Letter No. **B2/2655/2000**

Sub: CMDA - Area Plans Unit - Planning Permission -
Proposed construction of GF+3Floor residential
building with 16 dwelling units at T.S.No.4/75,
Block No.45 of Puliyur Village in Plot No.11,
Rathinammal Street, Kodambakkam, Chennai-24 -
Development Charges Advice sent - Regarding.

CONSTRUCTION OF  
 RESIDENTIAL FLATS  
 AT PONDANATHI No. 1  
 RATHNAMMAL STREET  
 PULIYAR VILLAGE  
 KODAMBAKKAM, S.S.  
 CHENNAI-600026  
 T.S. NO. 4/75,  
 IN BLOCK NO. 45,  
 PULIYAR VILLAGE,  
 EGMORE-NUNGAMBAKKAM  
 TALUK.  
 Revised Plan  
 Dt. 12/12/00

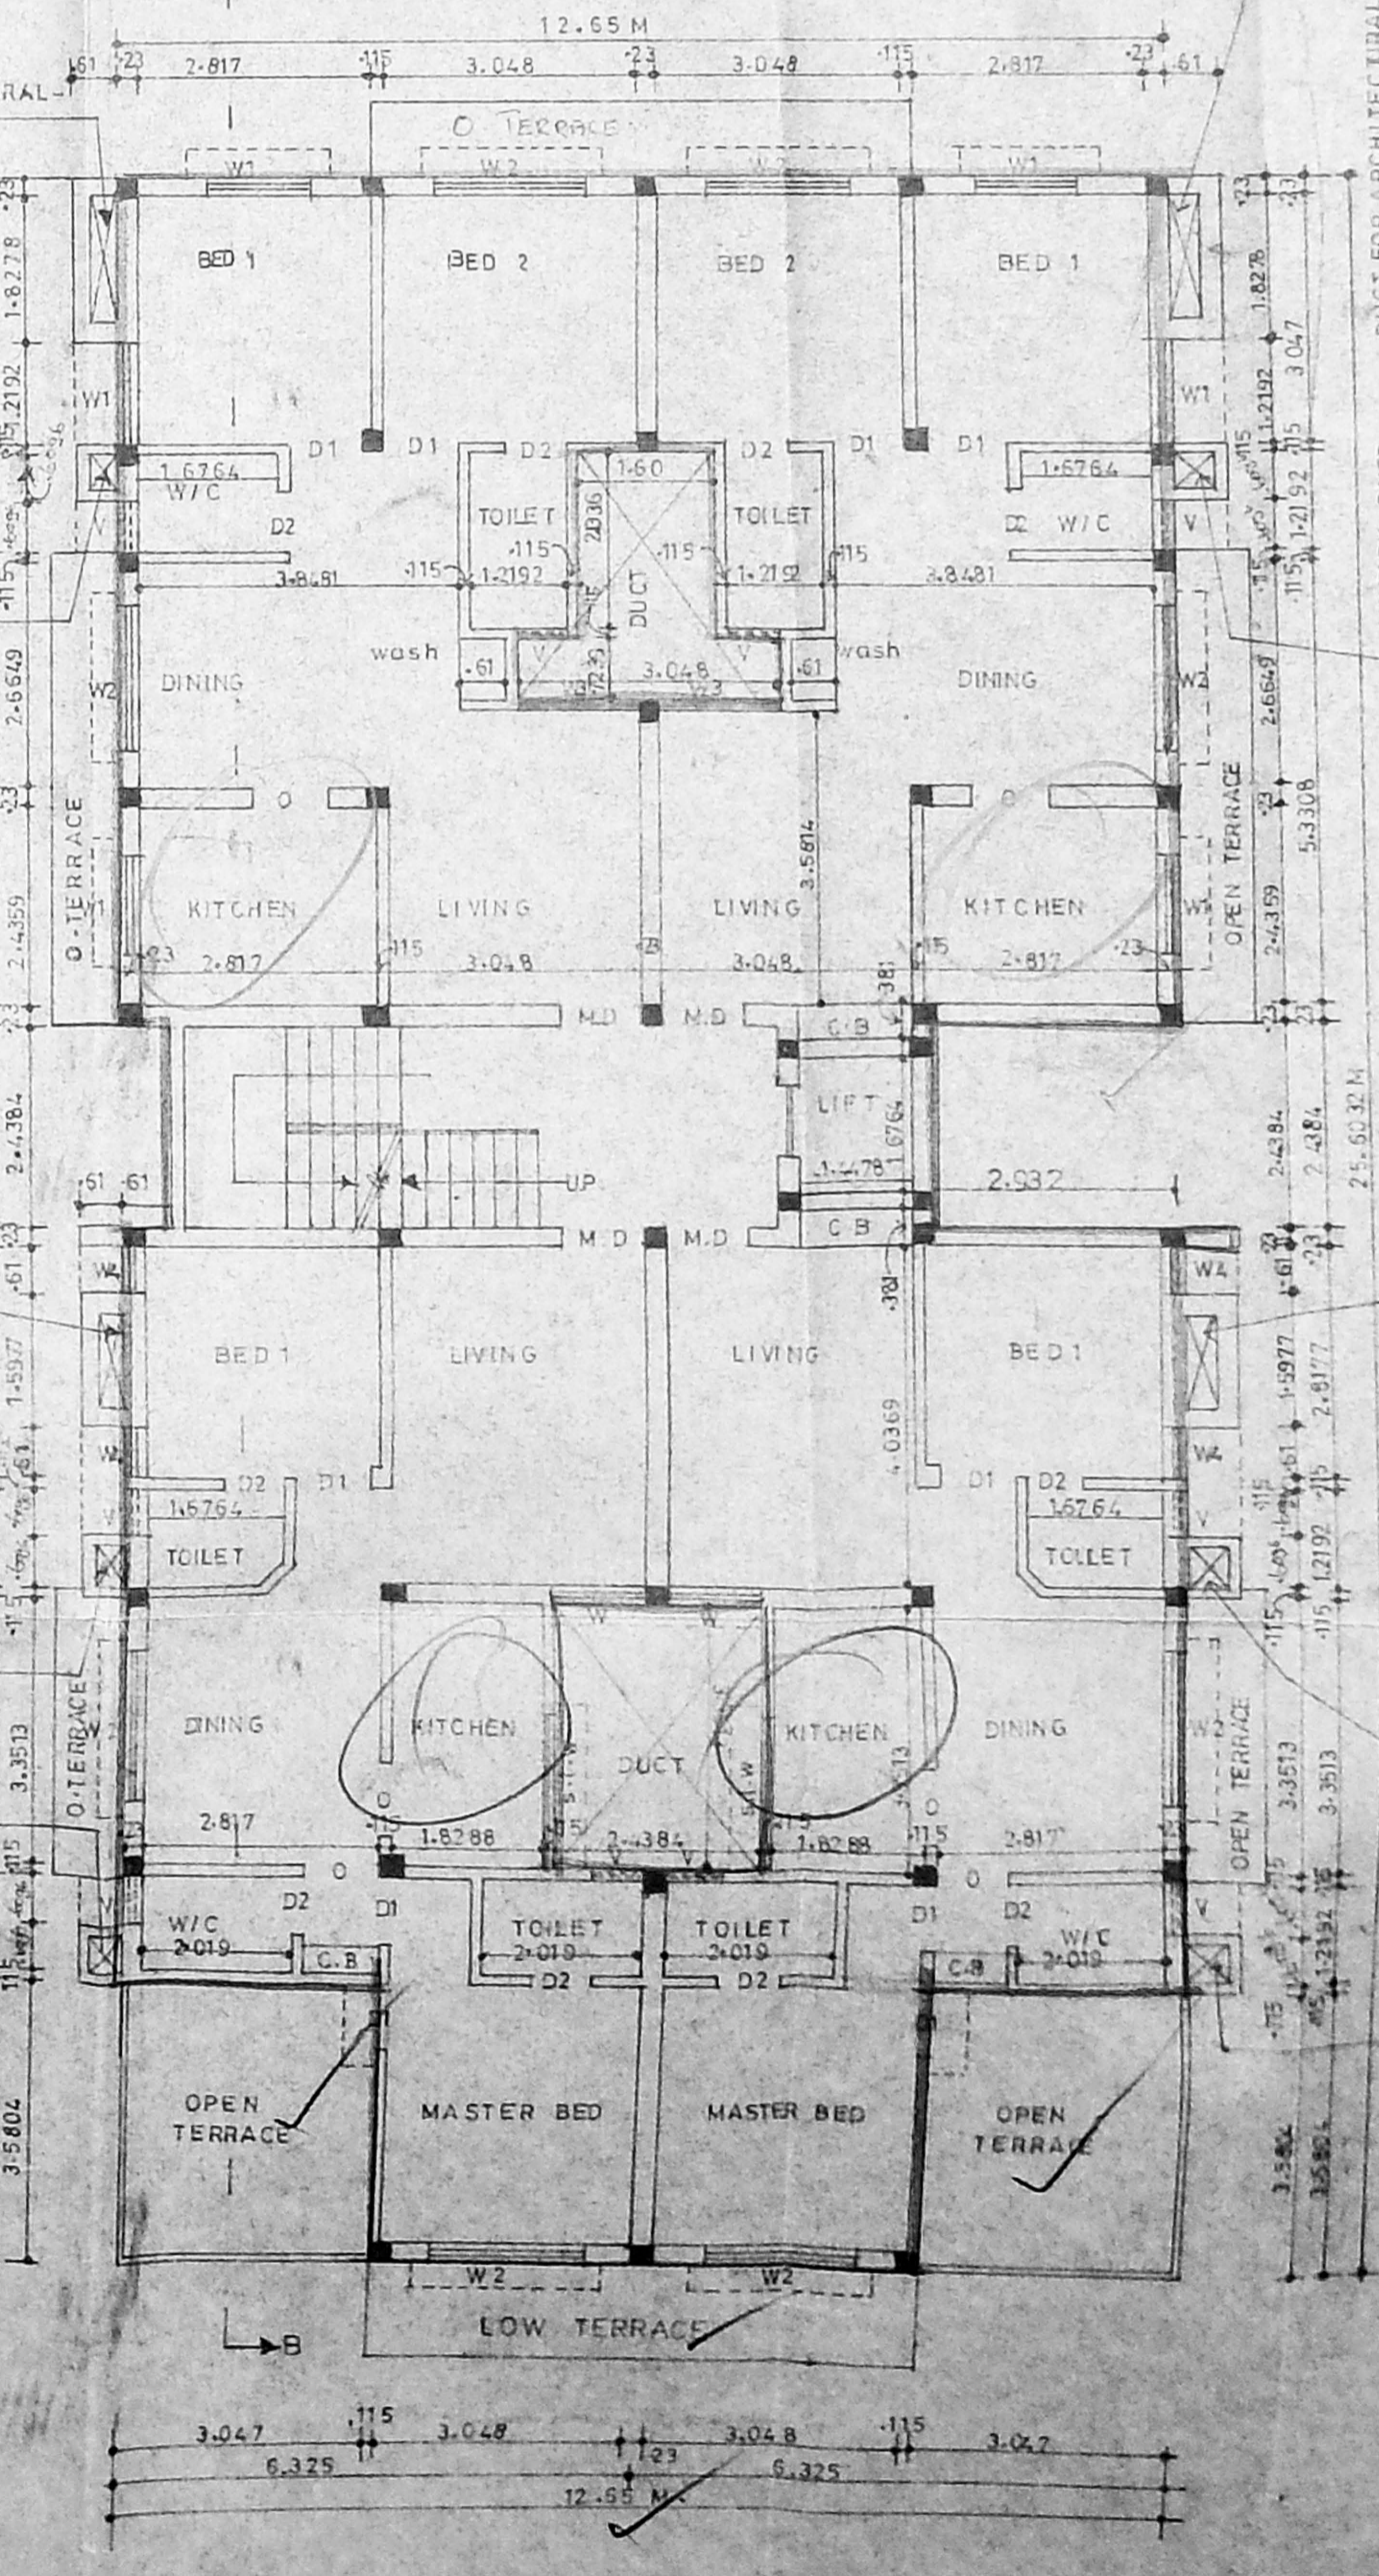
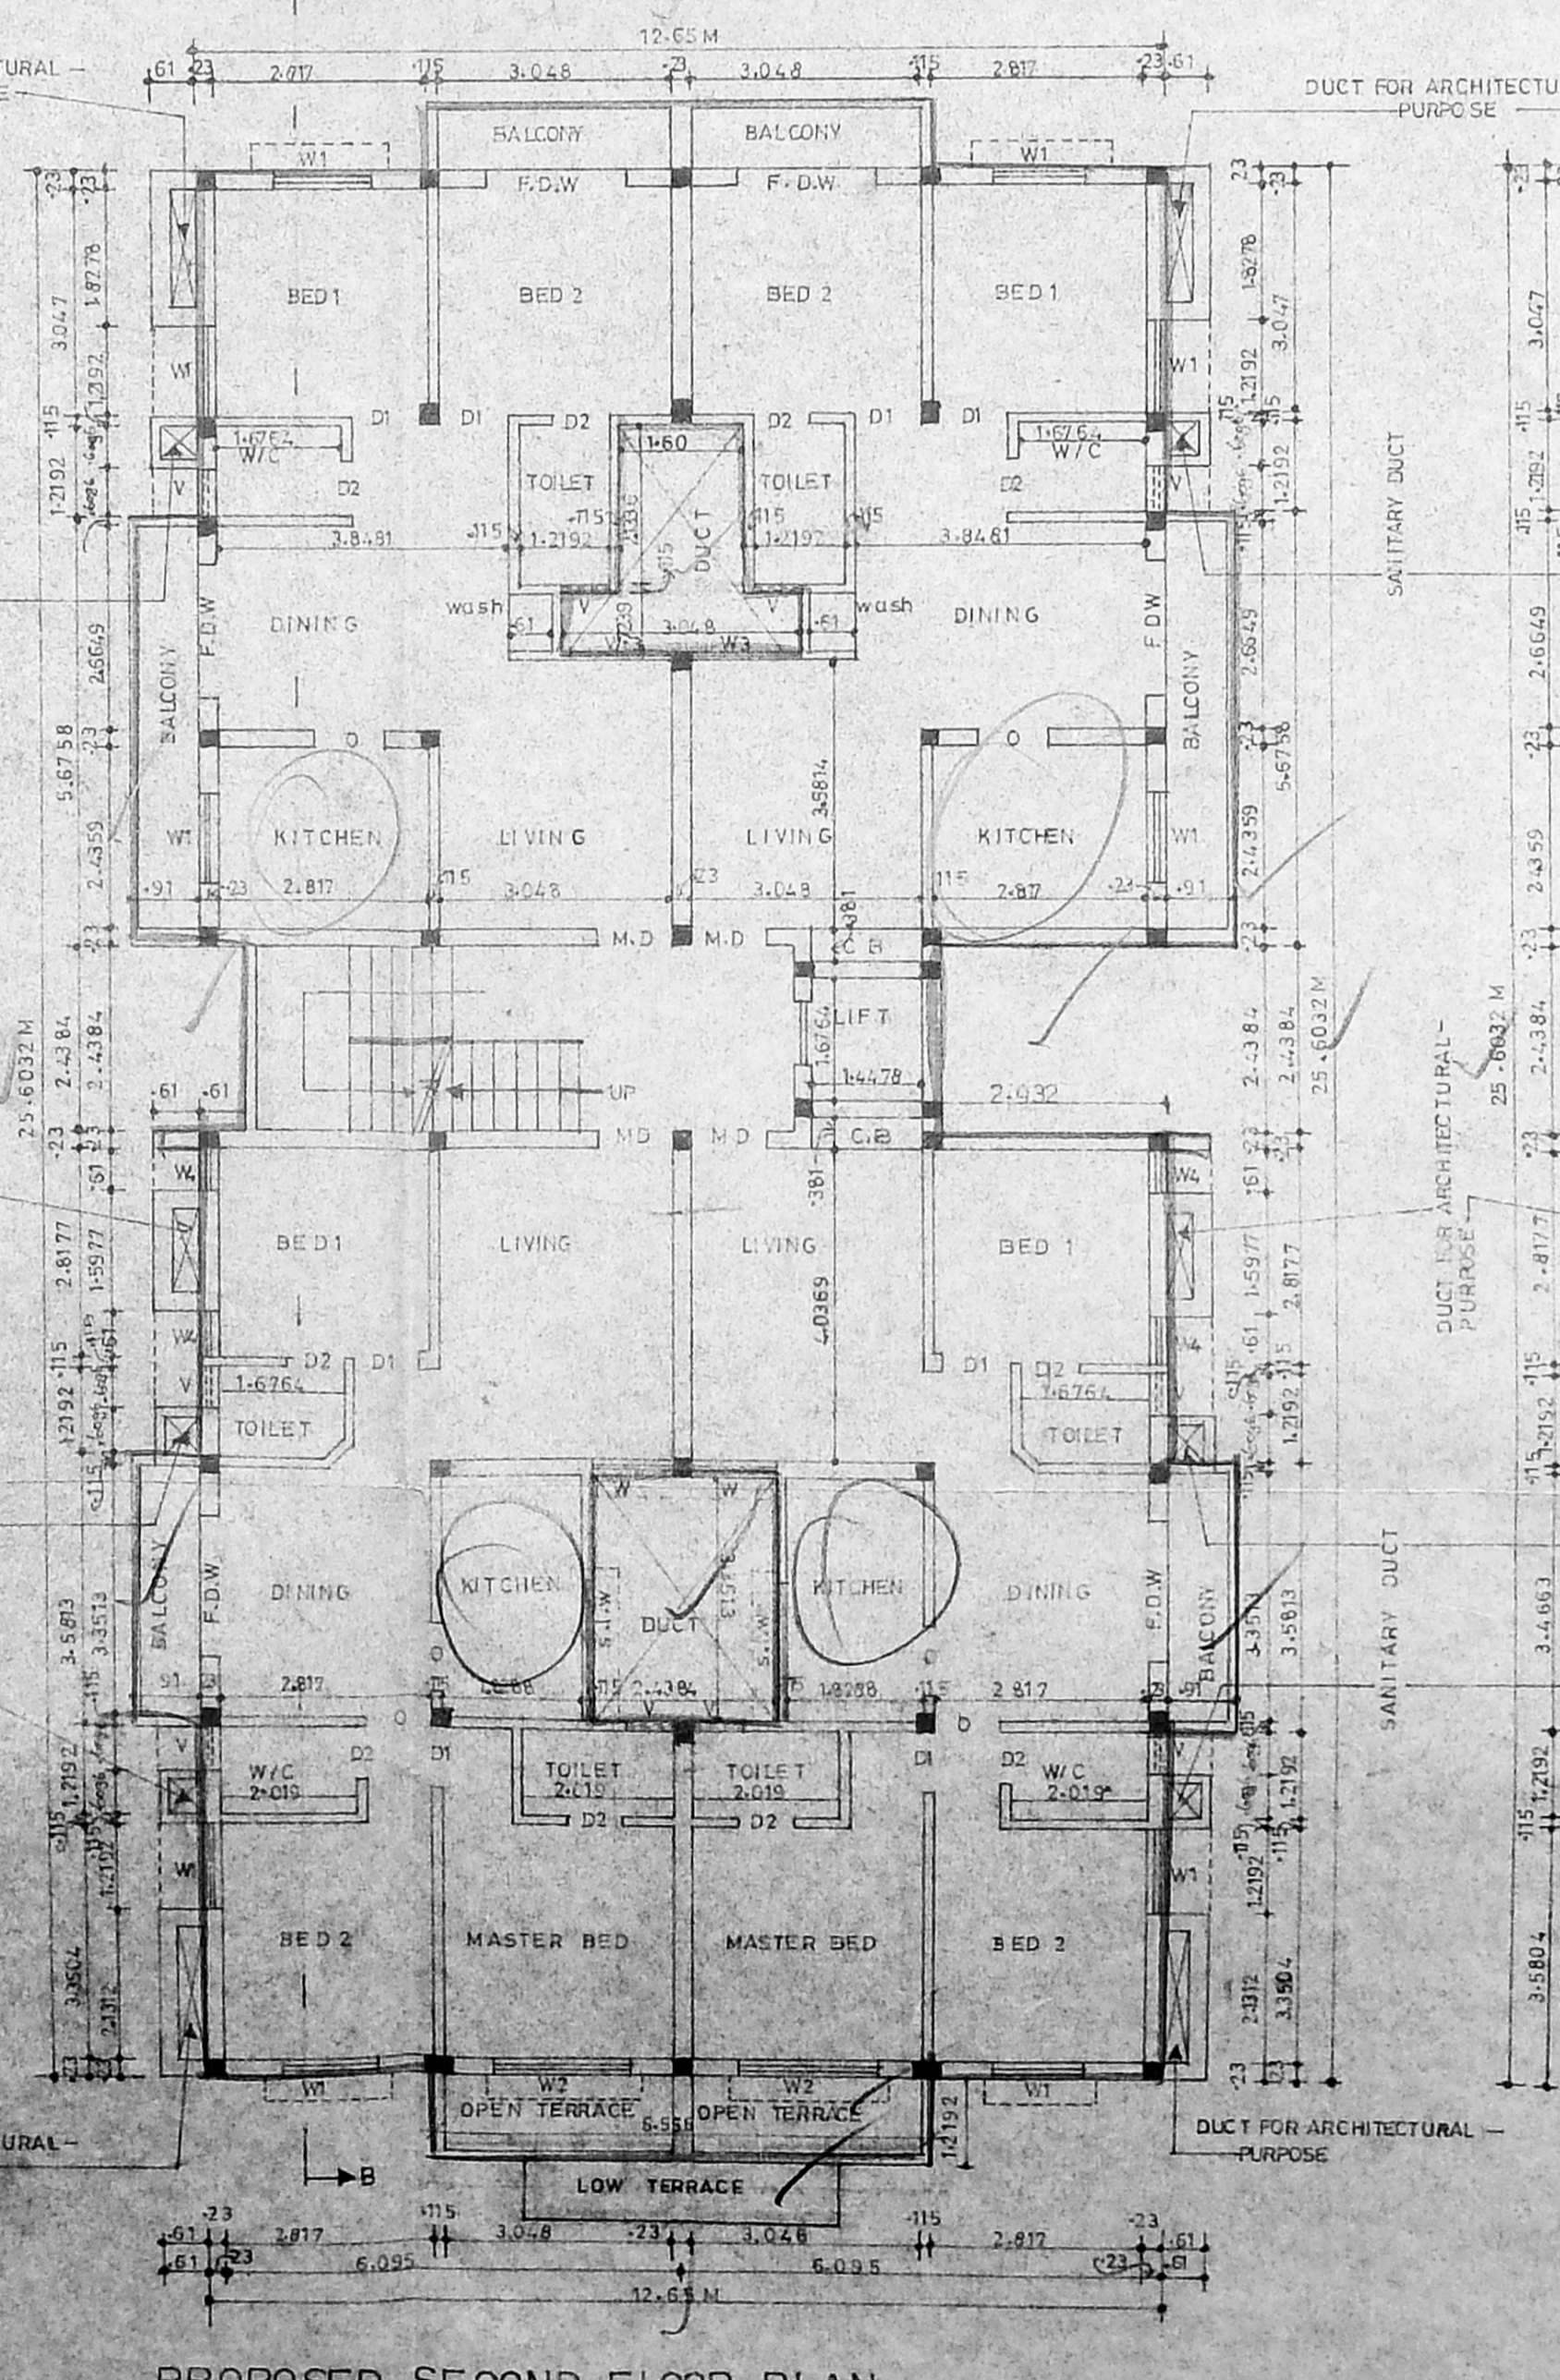
(***) 1.2) Revised plan rectifying the following defects:-

- a) Mention the low terrace portion in 2nd floor plan and 3rd floor plan.
- b) Licensed Surveyor signature in the plan.
- c) Marking the car parking lots in the site plan in confirming with Development Control Rules.
